**KIRKLEES METROPOLITAN COUNCIL
INVESTMENT & REGENERATION SERVICE**

**DELEGATED DECISION FOR APPLICATION FOR CERTIFICATE OF
LAWFUL DEVELOPMENT**

Reference no.: 2023/CL/93012/W

Site: 2, Millwright Close, Marsden, Huddersfield, HD7
6EQ

Scale: AS SHOWN (at A1) Drawing Number: Revision:
Date: June 2023 **37/2431/04F**
Drawn: R.J.H.

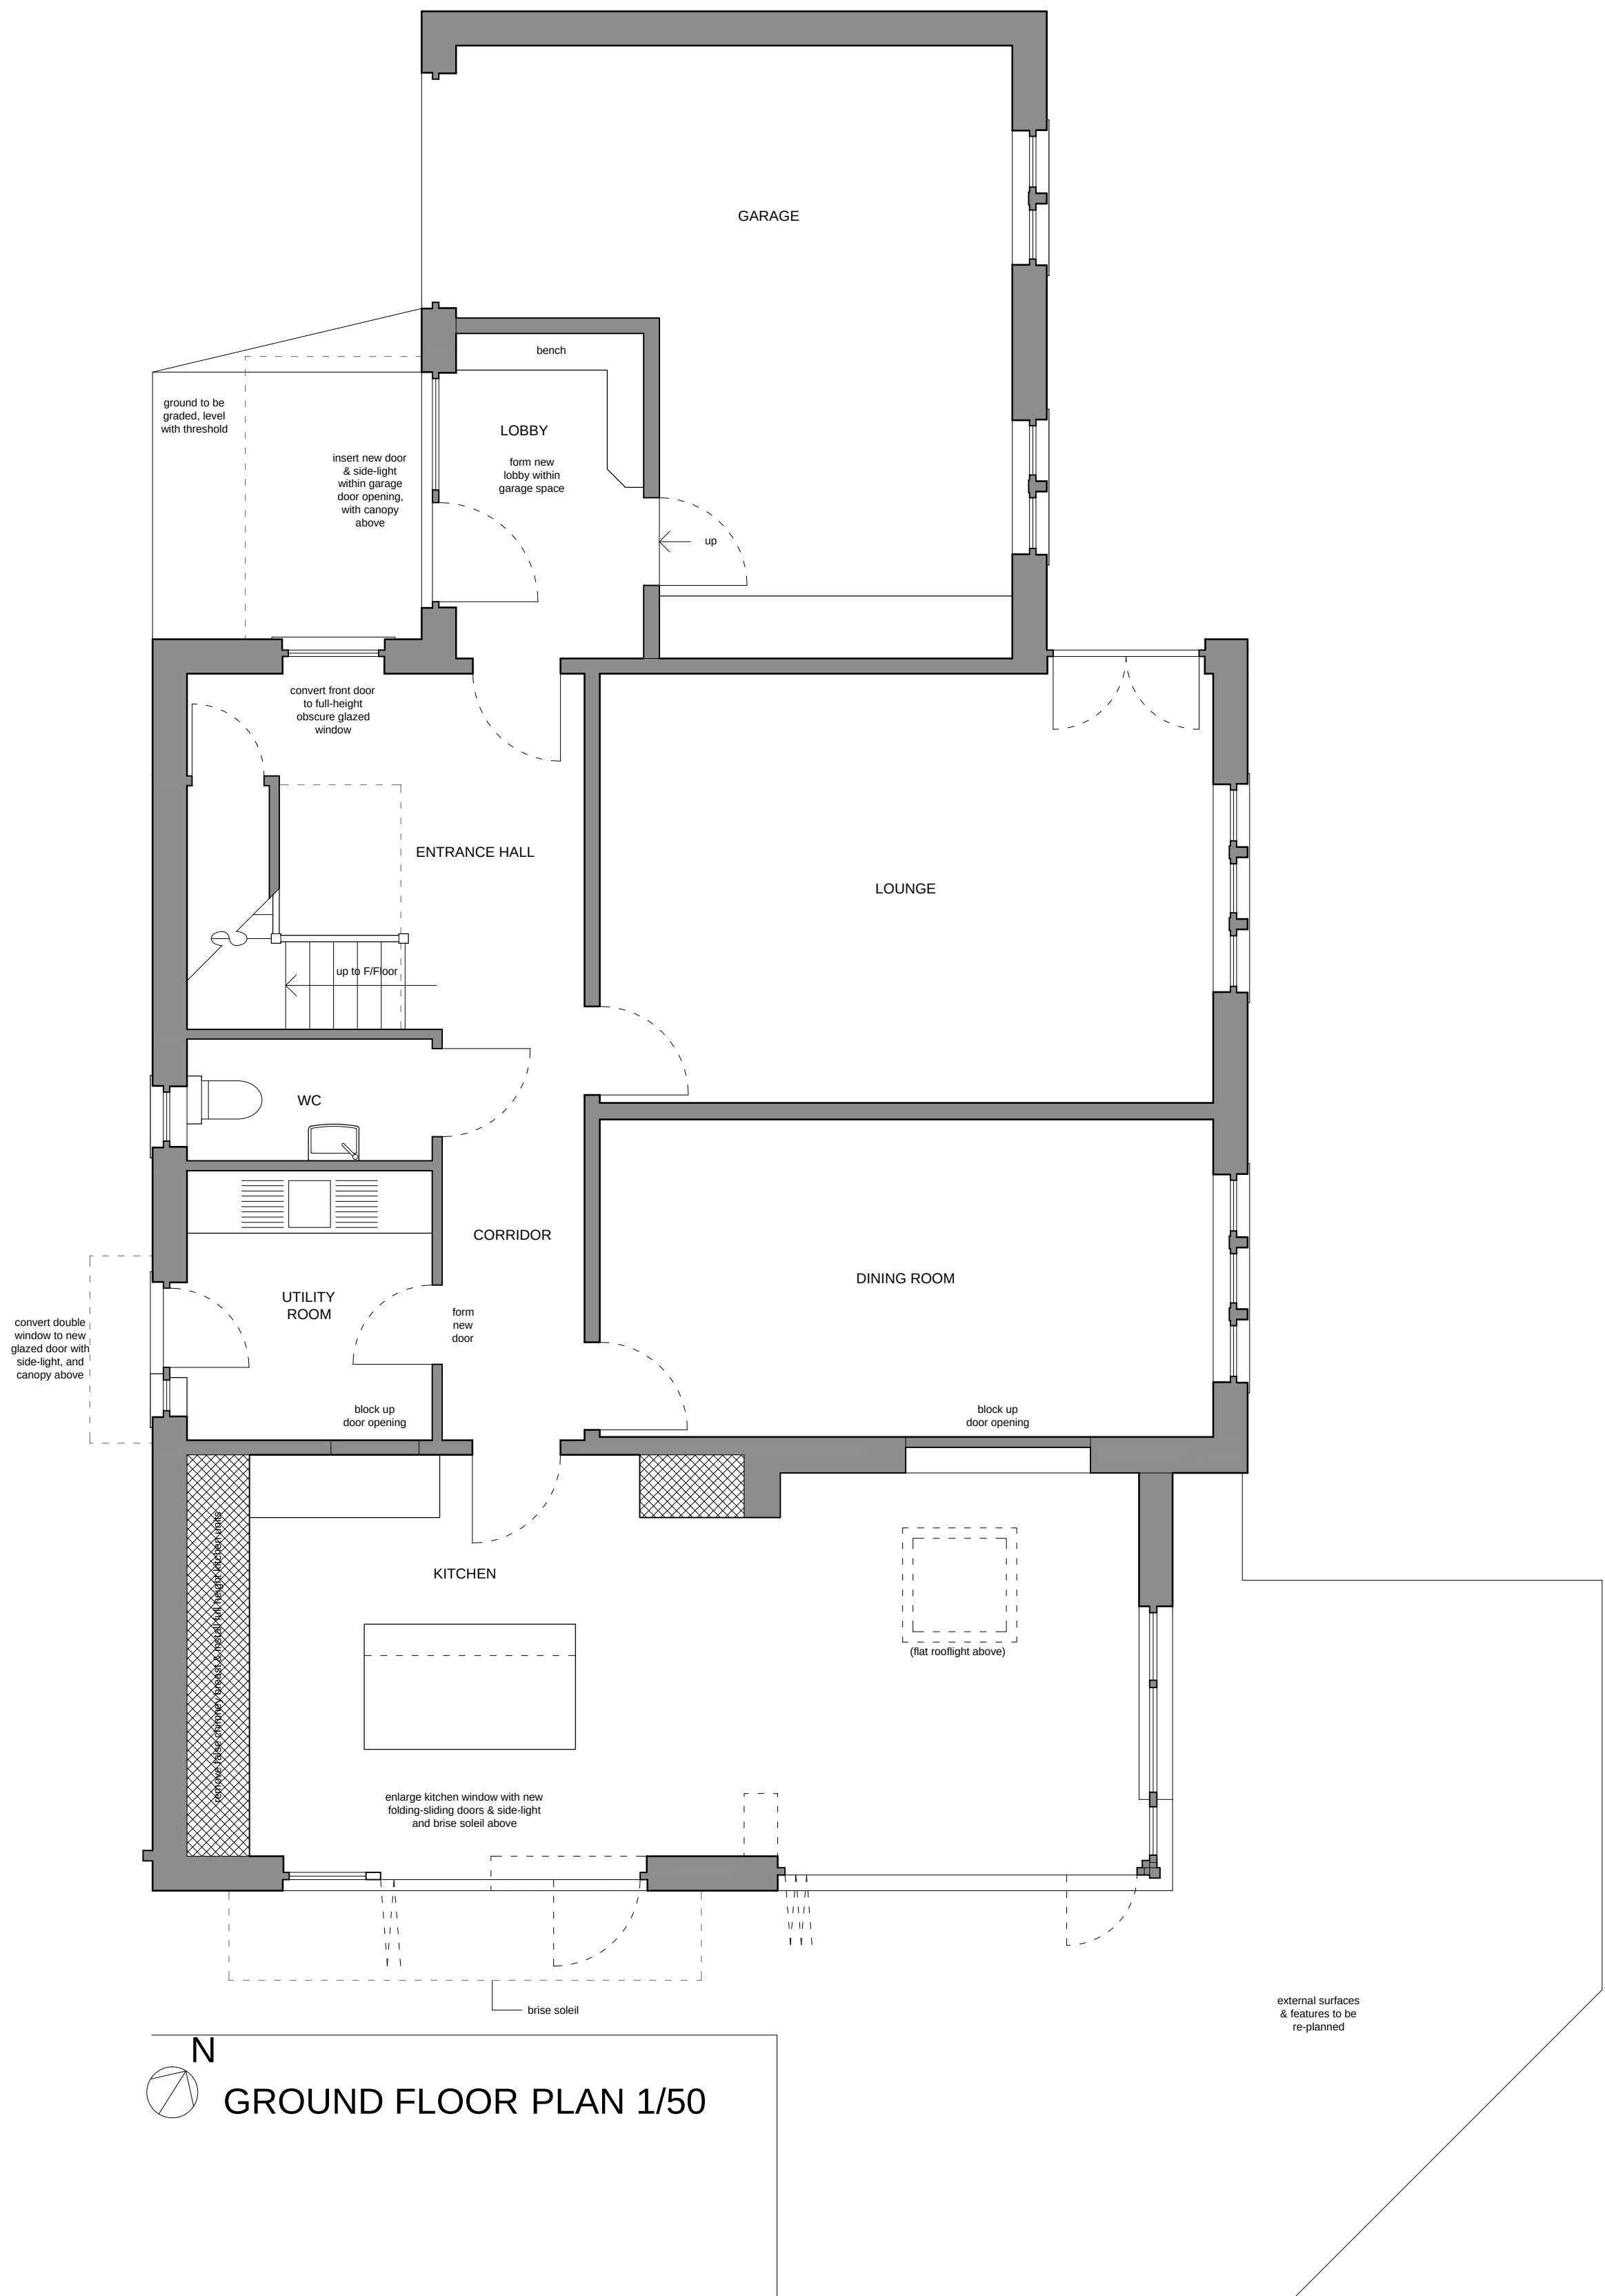
The extension would project from the rear elevation of the property by 3.8 metres and would be a total width of 4 metres rising to an overall height of 2.7 metres to the flat roof.

The extension would be constructed from stone to match the existing dwelling.

Comment: *the extension would not exceed 50% of the curtilage around the original dwellinghouse.*

Comment: *the height of the extension would not exceed the height of the roof of the existing dwellinghouse.*

Comment: *the height of the eaves would not exceed the height of the eaves of the existing dwellinghouse.*

Comment: *the extension would not extend beyond a principal elevation. The side elevation does not front a highway.*

Comment: *the dwelling is detached and does not extend more than 4 metres or exceed 4 metres in height.*

Comment: *the dwelling is detached and does not extend beyond the rear wall by more than 8 metres and does not exceed 4 metres in height.*

Comment: *the enlarged part of the dwellinghouse does not have more than a single storey and is not within 7 metres of any boundary of the curtilage of the dwellinghouse.*

Comment: *the extension would not be within 2 metres of the boundary of the curtilage of the dwellinghouse and the height of the eaves would not exceed 3 metres.*

Comment: *the extension does extend beyond a wall forming a side elevation of the original dwellinghouse and although would not exceed 4 metres in height, have more than a single storey or have a width greater than half the width of the original dwellinghouse.*

Comment: *the construction materials listed on the proposed plan match the existing materials of the dwelling and no upper-floor windows located in a wall or roof slope are proposed.*
